THE ILEX CONSERVATION GROUP
To preserve the beauty and present character of Goring

18th November 2013

Reference FG/134/13 : Demolition of existing single storey dwelling, construction of paved display and parking forecourt, with associated landscaping and lighting at The Bungalow Hangleton Lane Ferring BN12 6PB

Client
PEUGEOT MOTOR COMPANY plc
Project
Yeomans
Littlehampton Road
Ferring
Worthing
BN12 6PB
Drawing
PROPOSED EXTERNAL LIGHT PLOT
Drawn by Date Scale
CY SEP 2013 1:200
Drawing No. Revision
1541/4

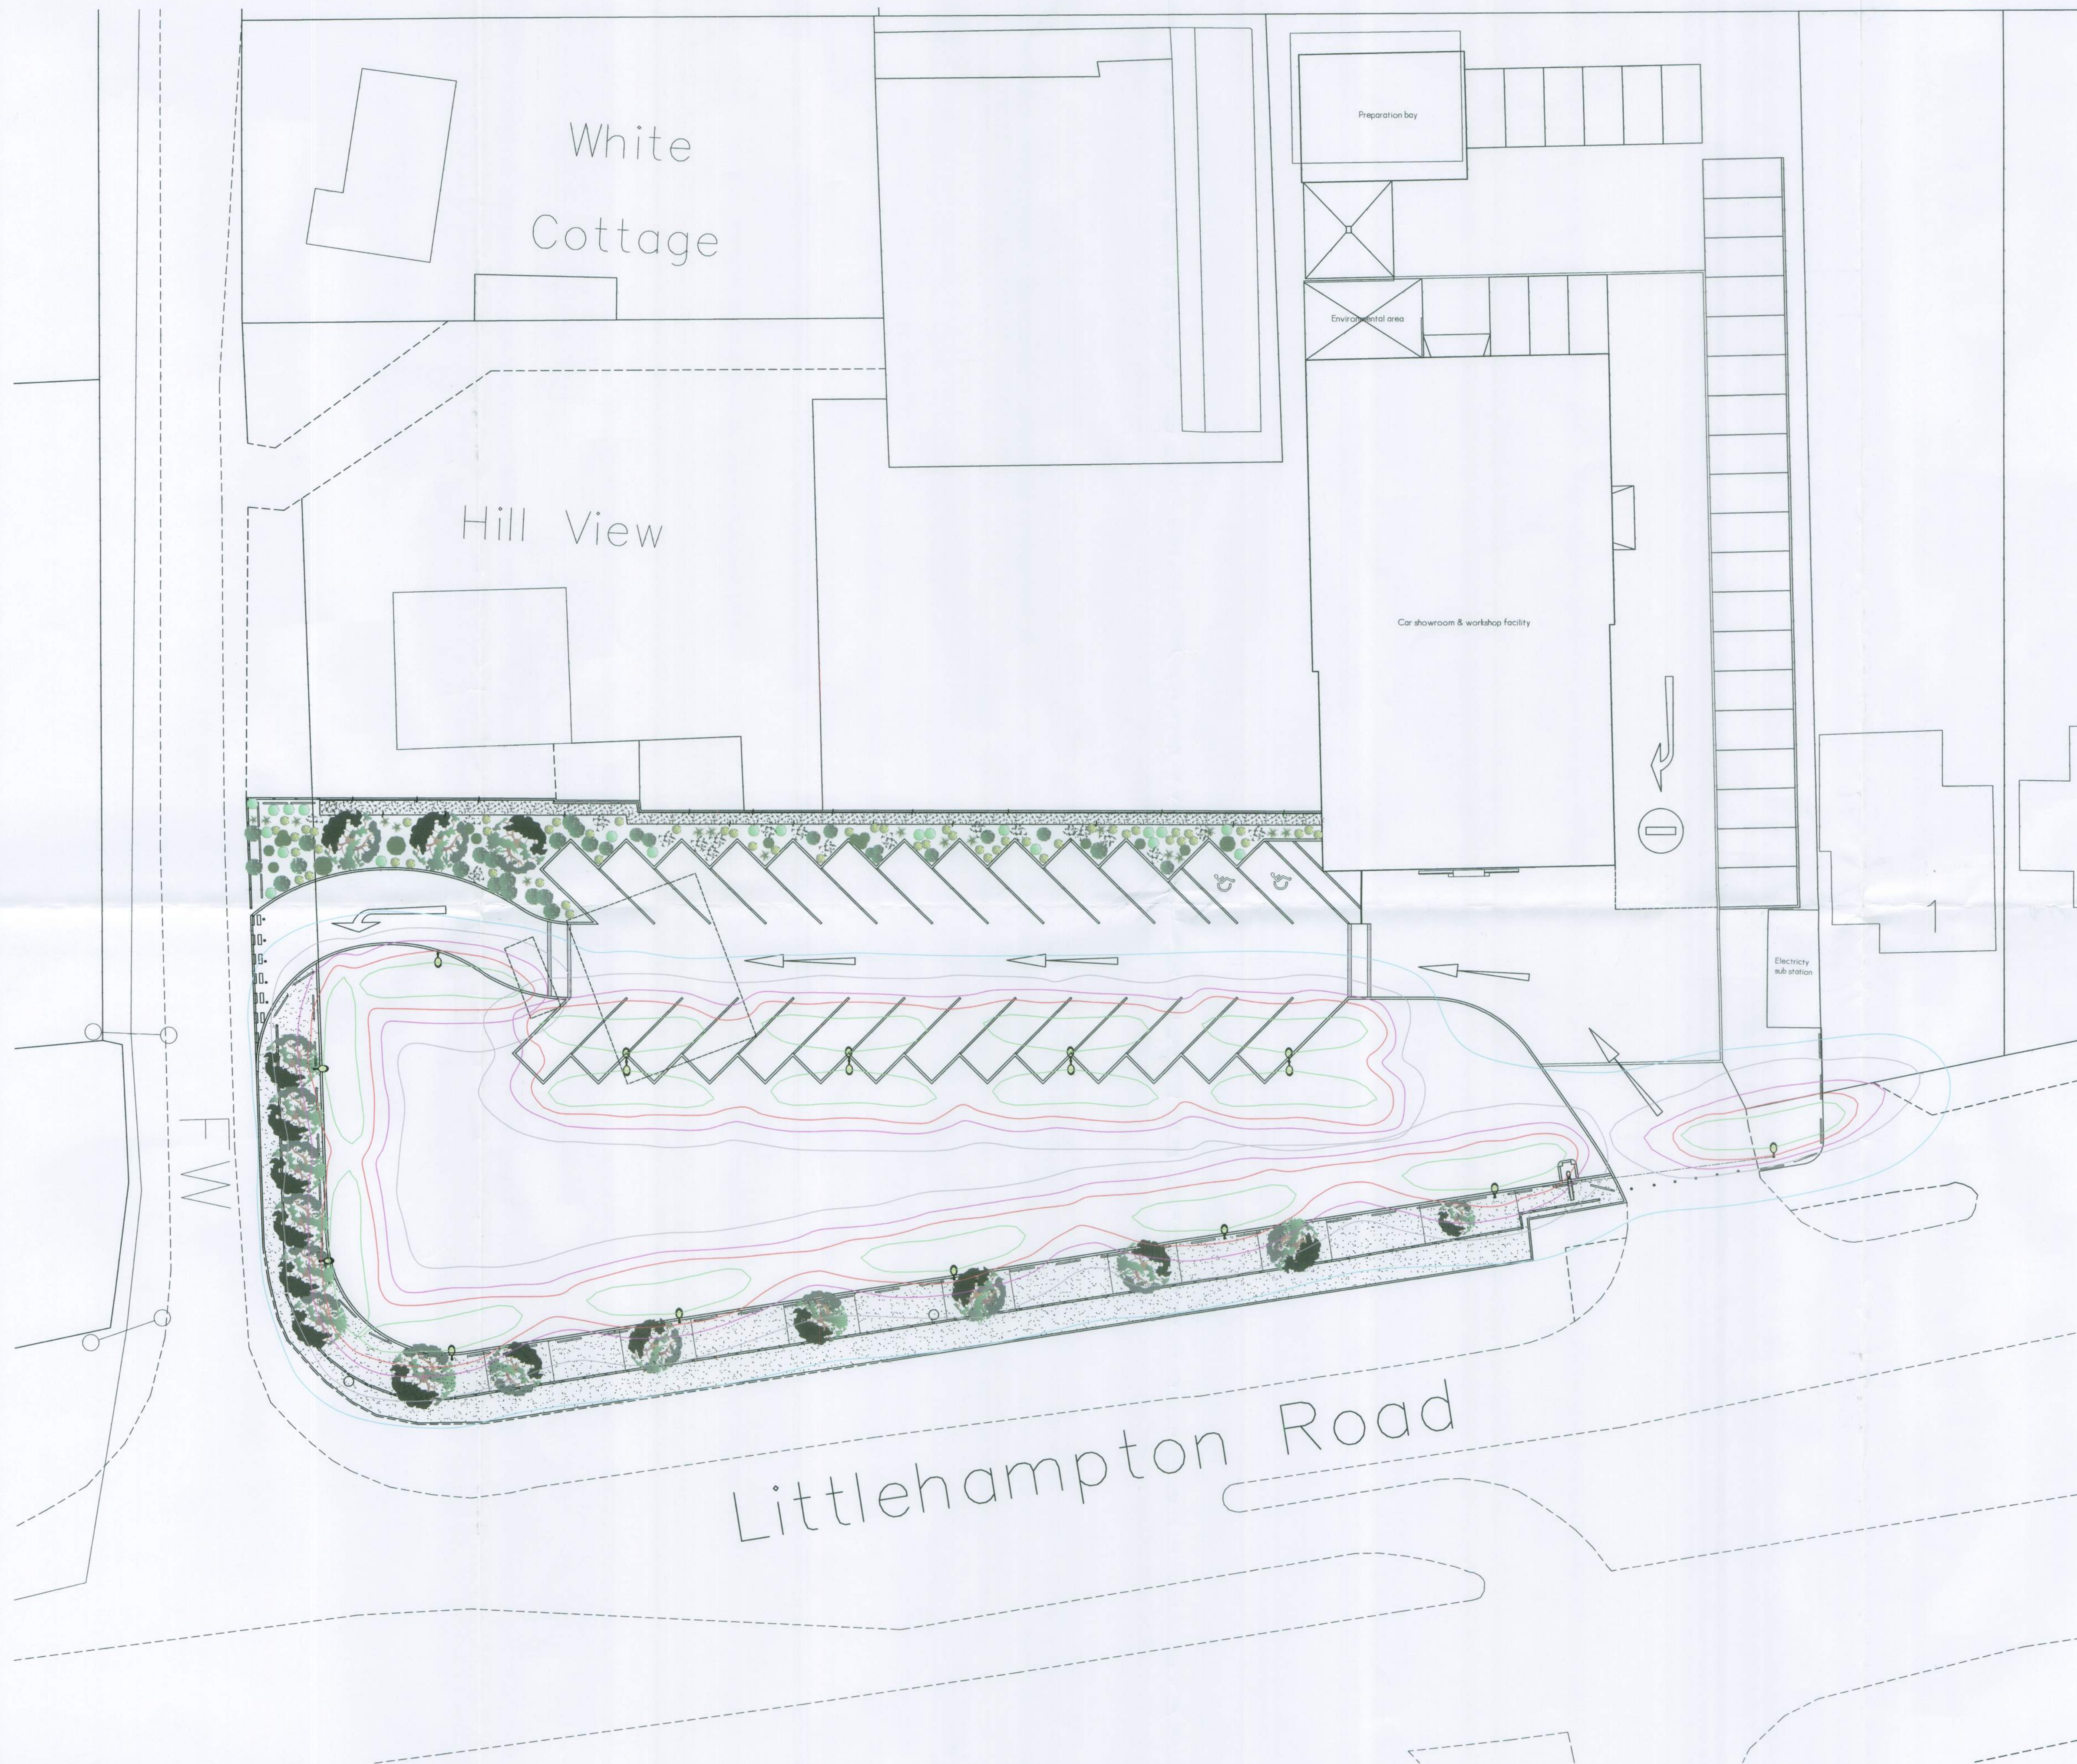
We believe that in replacing green space with hard standing, additional lighting and a large increase of vehicle parking, this application will not protect and enhance the quality of the environment and is therefore contrary to the Arun District Local Plan policy GEN7.

In looking at the detail of the application, we are disappointed that the opportunity has not been taken to ease the access to the garage from the proposed acute angle. We believe that this would lessen the hazard of vehicles slowing more than may be anticipated by other drivers when turning into the site. We also consider the telescopic bollards on the entrance a potential hazard to traffic as we feel that they may not be readily apparent to turning vehicles in the nearside lane when in use.
